## Application for Removal or Variation of a Condition following Grant of Planning Permission or Listed Building Consent

Demolition of three dwellings (Nos. 14 and 16 Pield Heath Road and 2 Pield Heath Avenue) and one Bed and Breakfast (No. 18 Pield Heath Road), and the subsequent erection of a part two, part three storey (plus basement) 60-bed care home, with 14 car parking spaces, landscaping and external amenity space.

76760/APP/2022/1889

We wish to vary Condition 2 to update drawings which allow installation of sub-station and louvered screening to the roof terrace for screening of the external plant equipment.

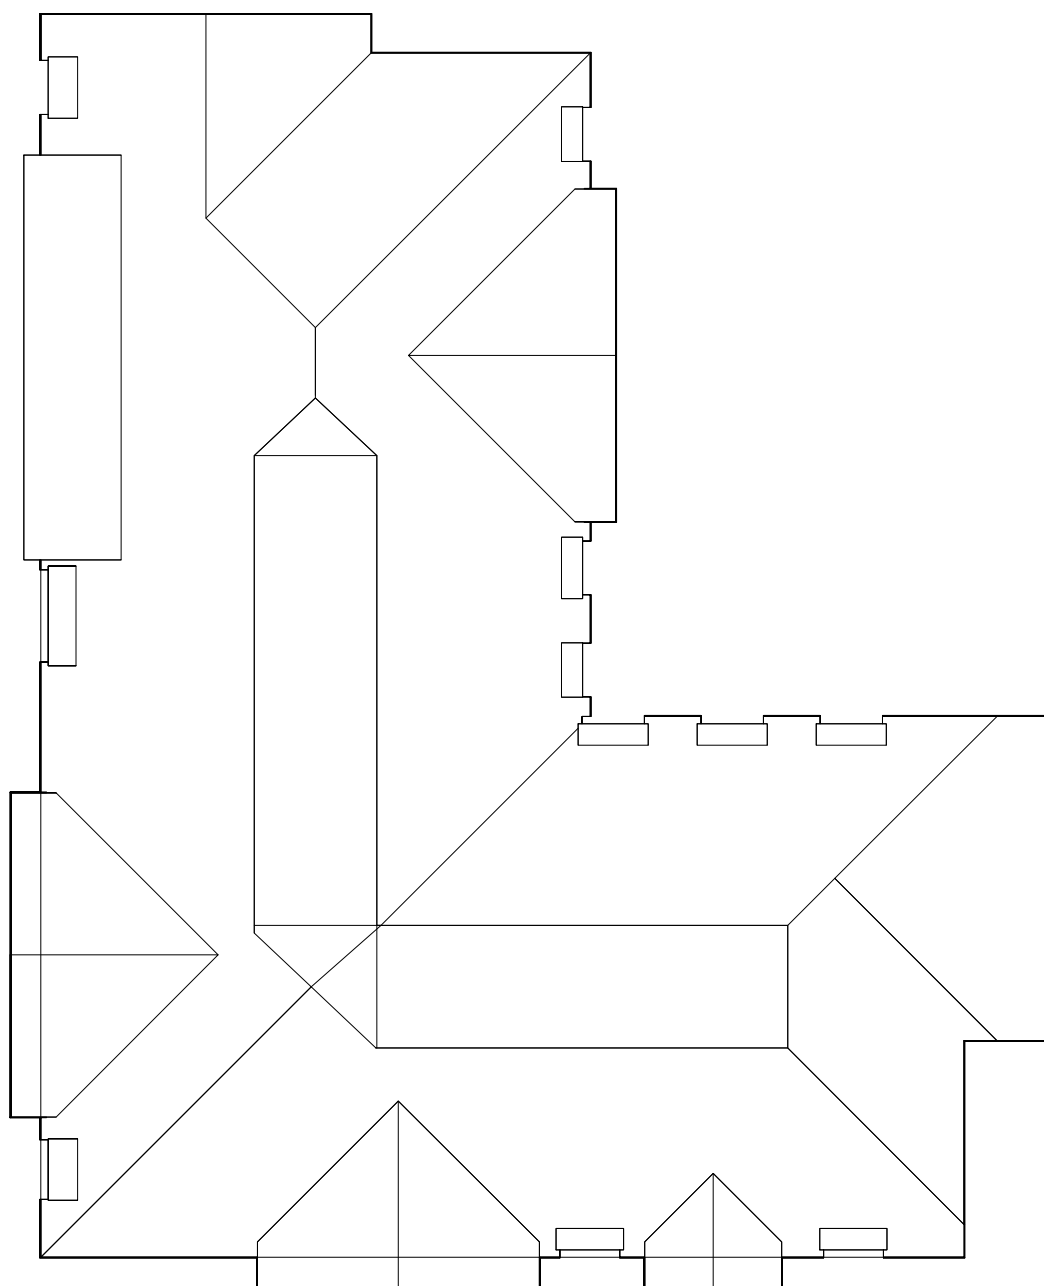
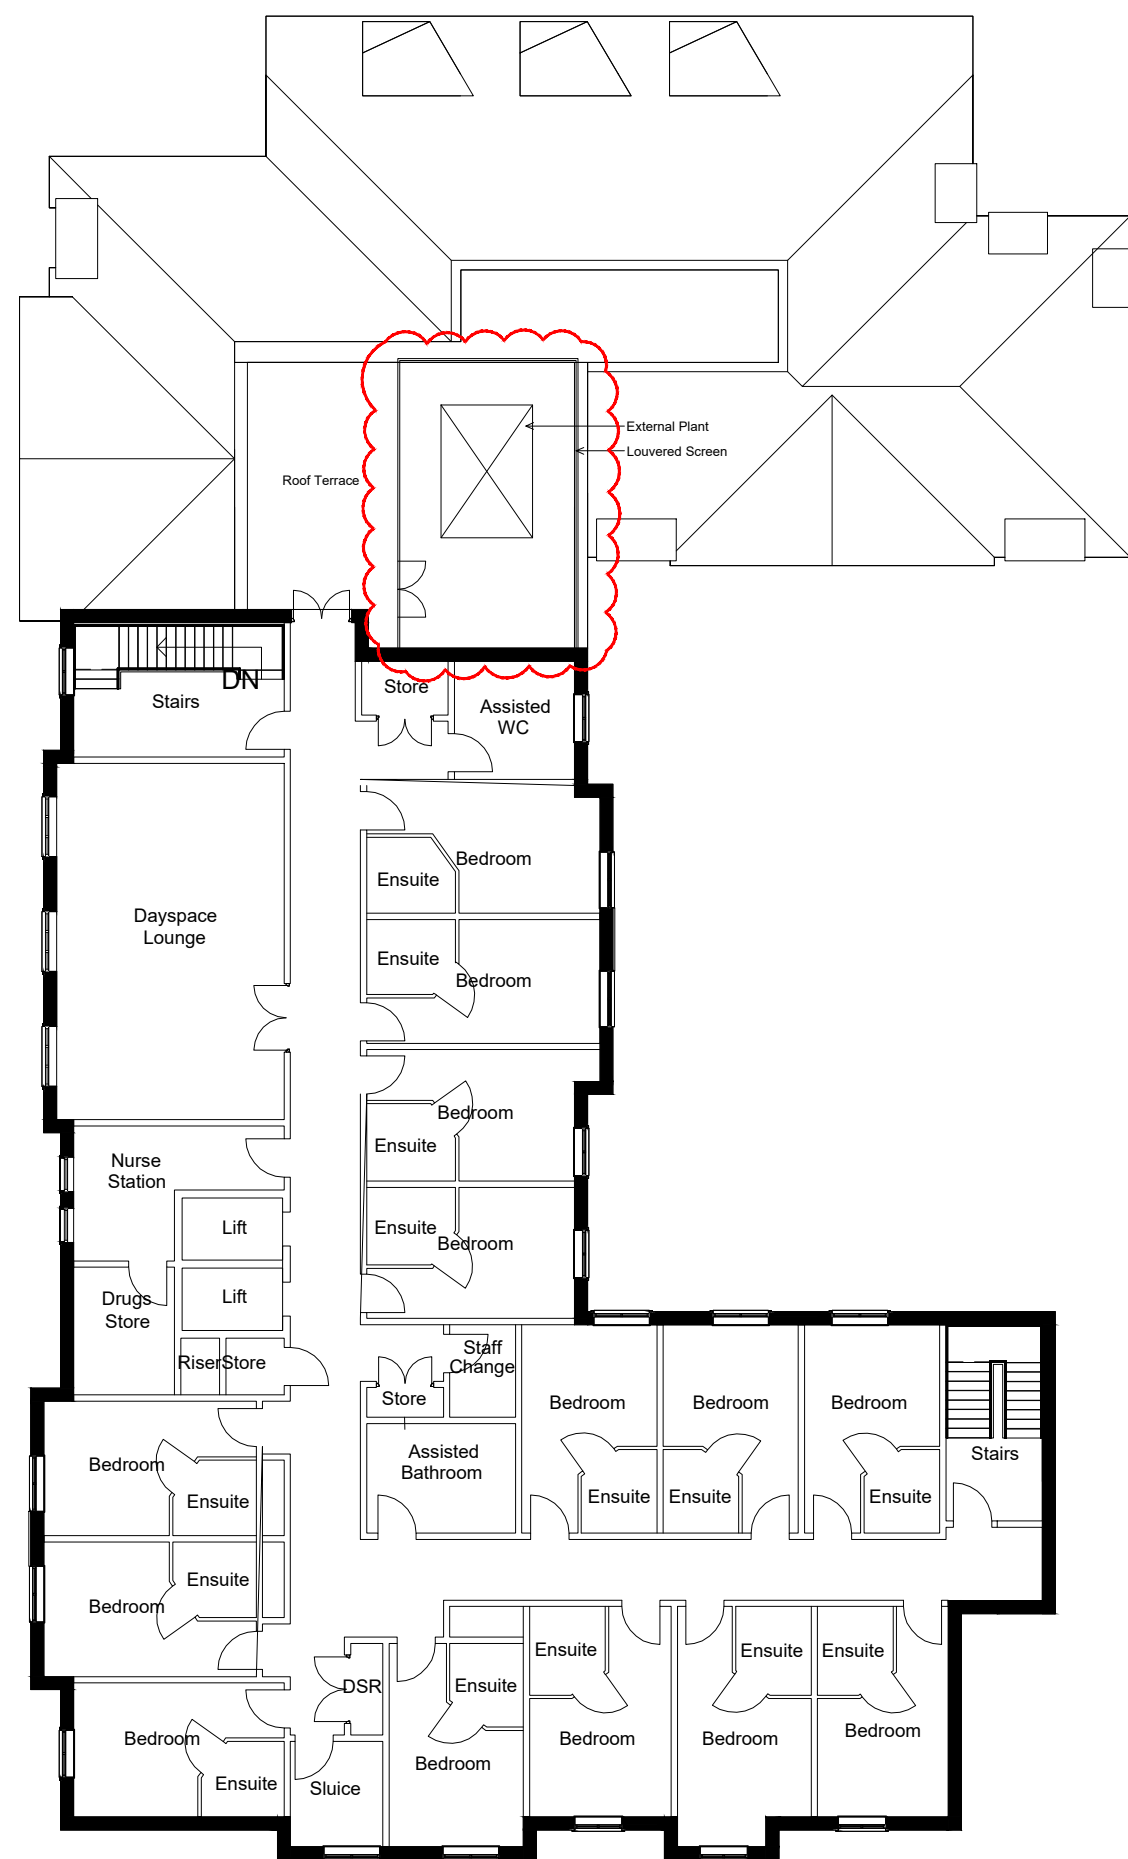
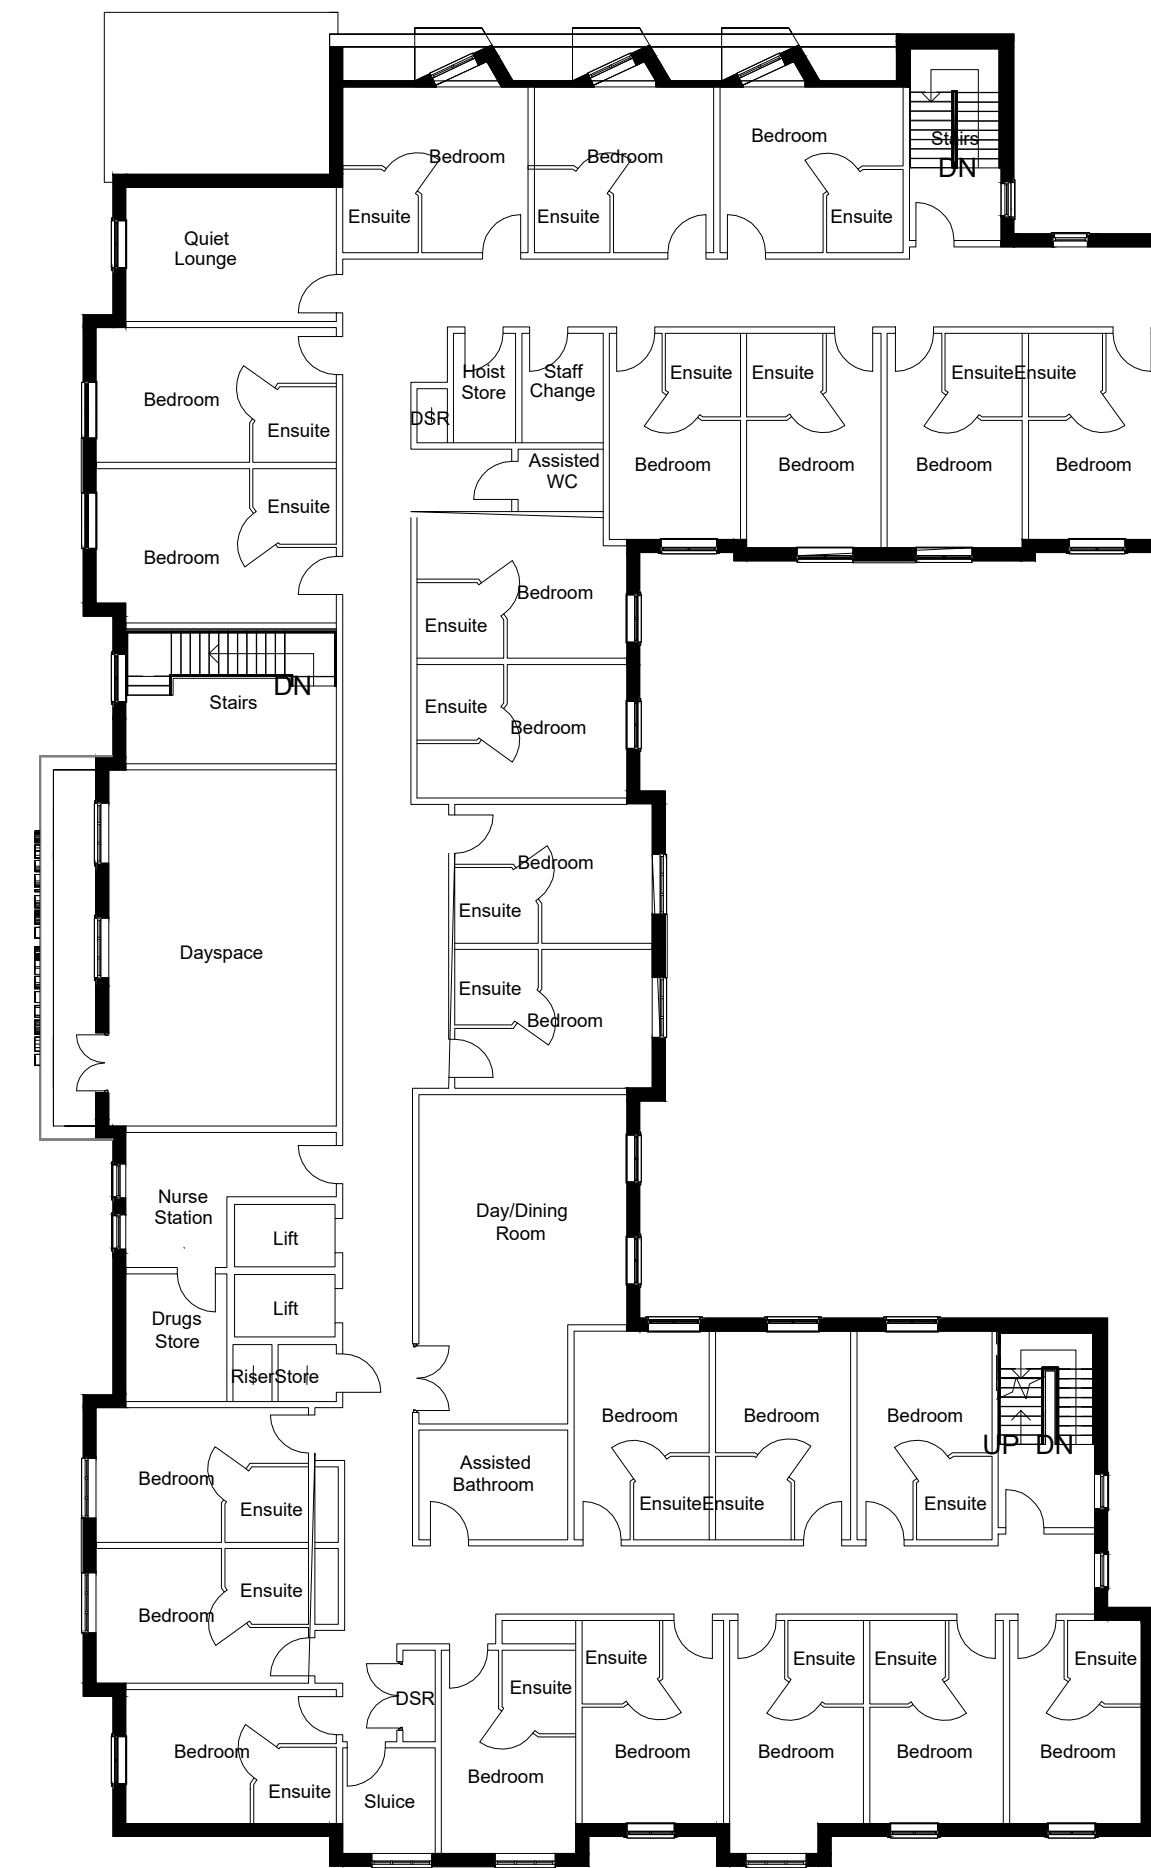
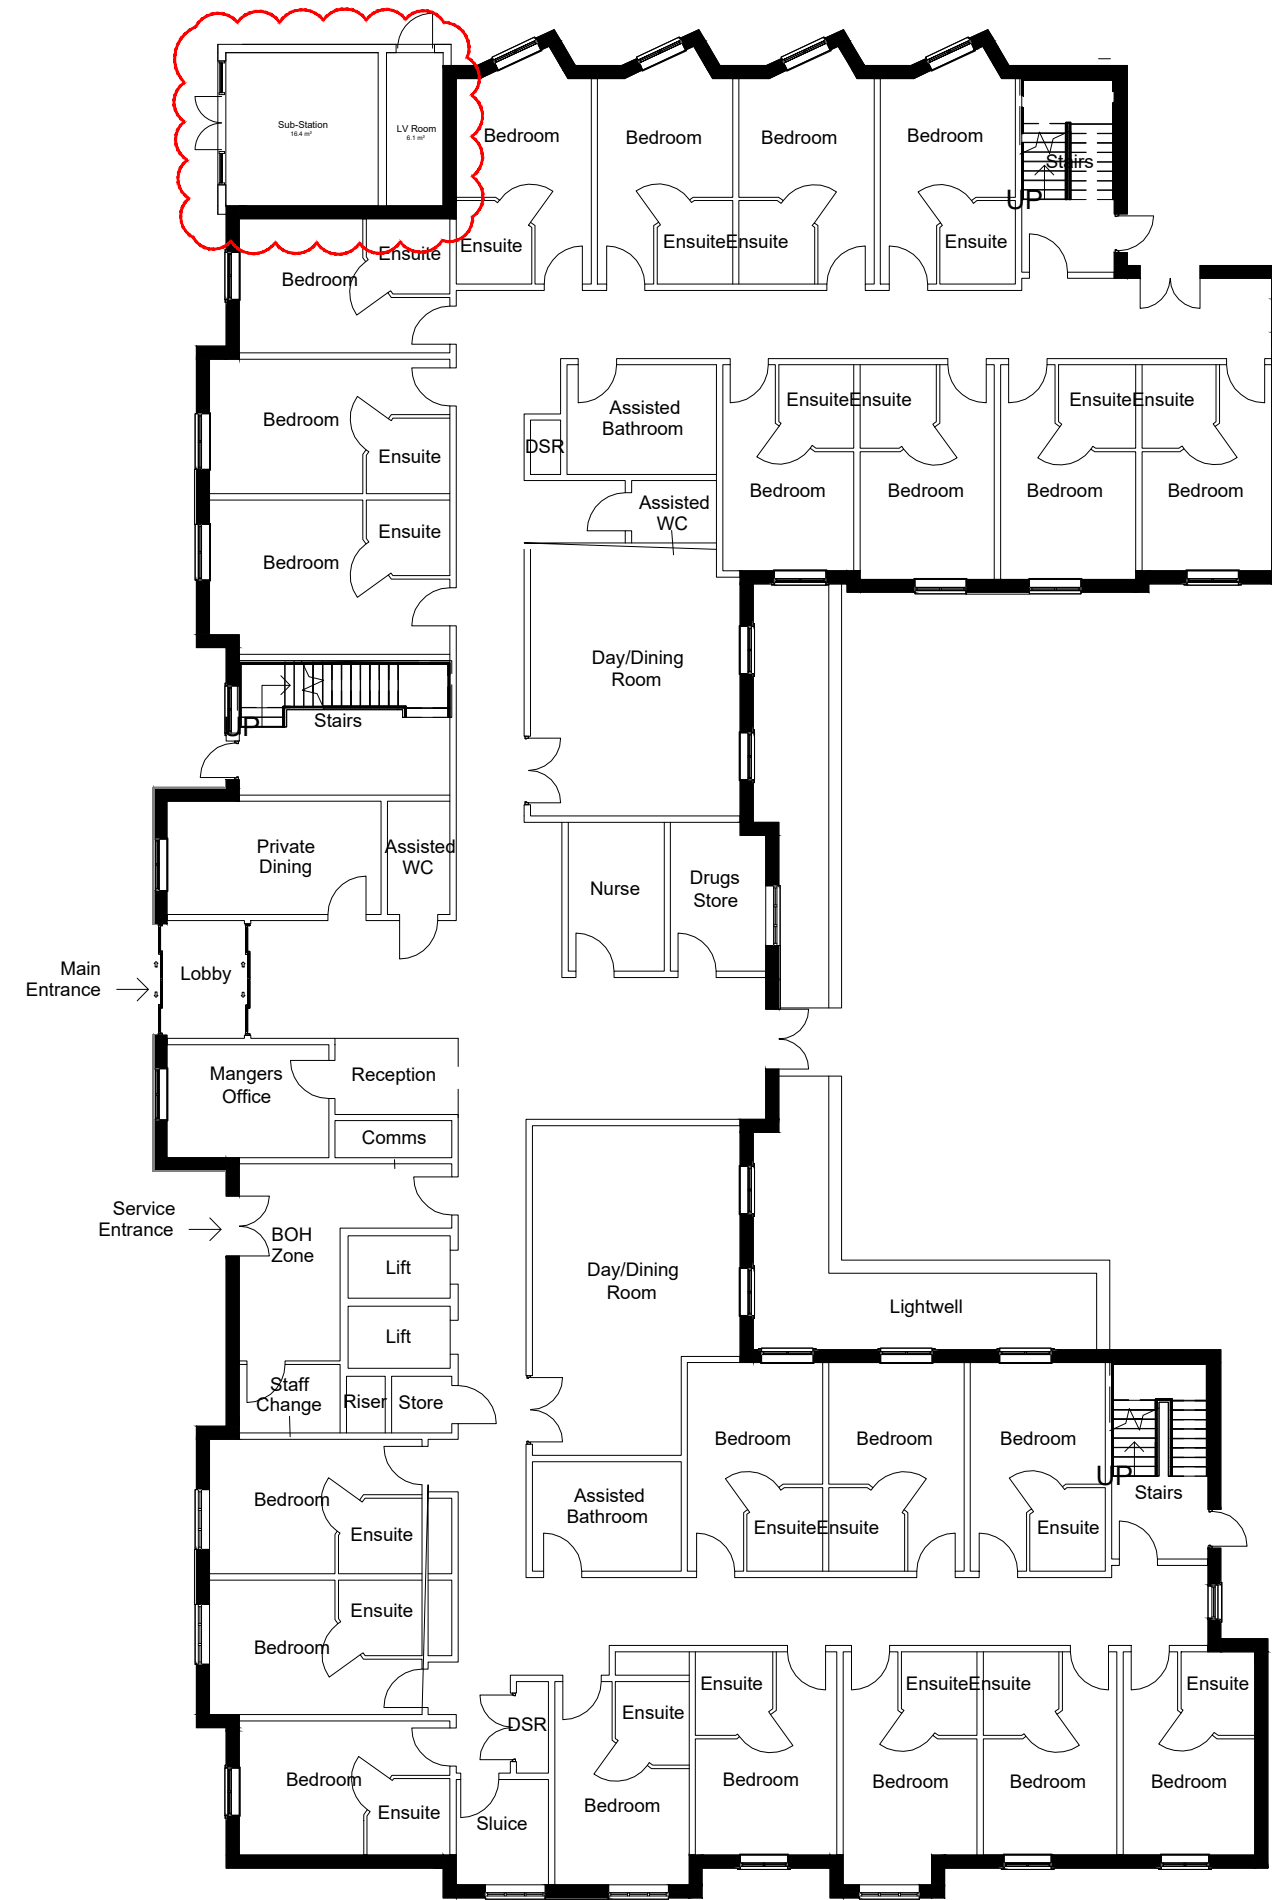
The sub-station was not shown on the original approval, we wish to have this added to the building using the same materials to minimise the visual impact. We wish to add louvred screens to the roof terrace to minimise the visual impact of external plant equipment

Condition 2 to be varied so that Drawings (NMA Reference 76760/APP/2024/1470 ) 9001 Proposed Site Plan, 0001 Proposed Floor Plans, 0102 Proposed South and West Elevations, 1010 Proposed North and East Elevations, become 9001 Proposed Site Plan RevA, 0001 Proposed Floor Plans RevA, 0102 Proposed South and West Elevations RevA, 1010 Proposed North and East Elevations RevA
